Application No: Y/31/21/PL  
Site Address: Land East of Drove Lane Yapton BN18 0EB  
Description of works: Temporary sales cabin & associated landscaping. This application may affect the setting of listed buildings, may affect the character & appearance of the Main Road/Church Road Conservation Area & is in CIL Zone 3 (Zero Rated) as other development.

Thank you for your internet representation made on 21st April 2021 which has been recorded as an objection with the comments as follows:

YPC has considered the above application and object to this application.

Figure 2. Snippet of Proposed Site Layout

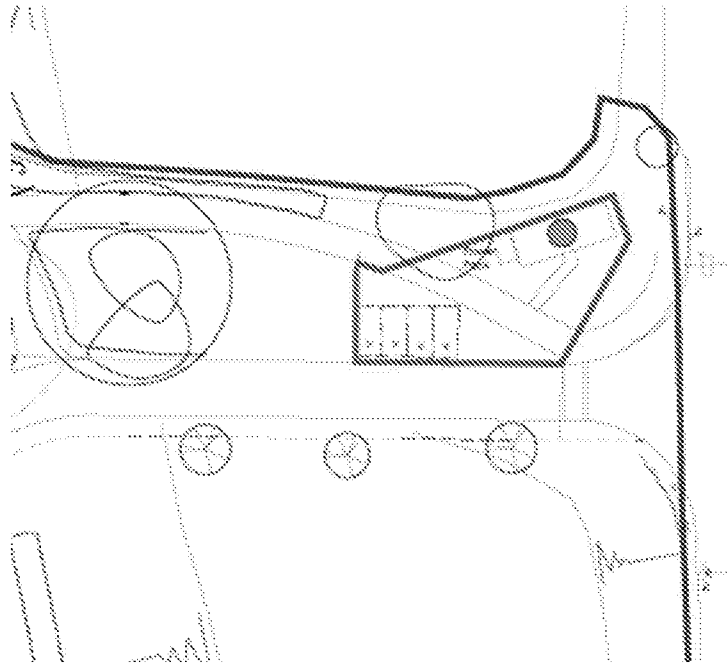
- The location of the site cabin is out of keeping with the open street scene of this section of Main Road and its adjoining conservation area. YPC is of the view that the sales cabin should be located within the main body of the proposed housing site. The cabin is sited within a zone that has been specifically left open for planning and aesthetic reasons. Whilst the cabin is temporary, the likely period of time of its being will extend to the life of the development programme which is estimated as 3+ years.

- YPC have grave concerns with the conflict of traffic with the nursery/scout hut and therefore believe that the sales cabin for safety reasons should be located within the actual site away from conflicting uses.

- YPC are concerned with traffic movements into the sales car park and its close proximity to the junction of Drove Lane with Main Road.
- YPC whilst appreciating that the sales cabin's prominence on Main Road helps with marketing believe that the applicant's proposed advertising flags and totem will be sufficient thus allowing the sales cabin to be located away from the designated open space, nursery and Main Road junction.
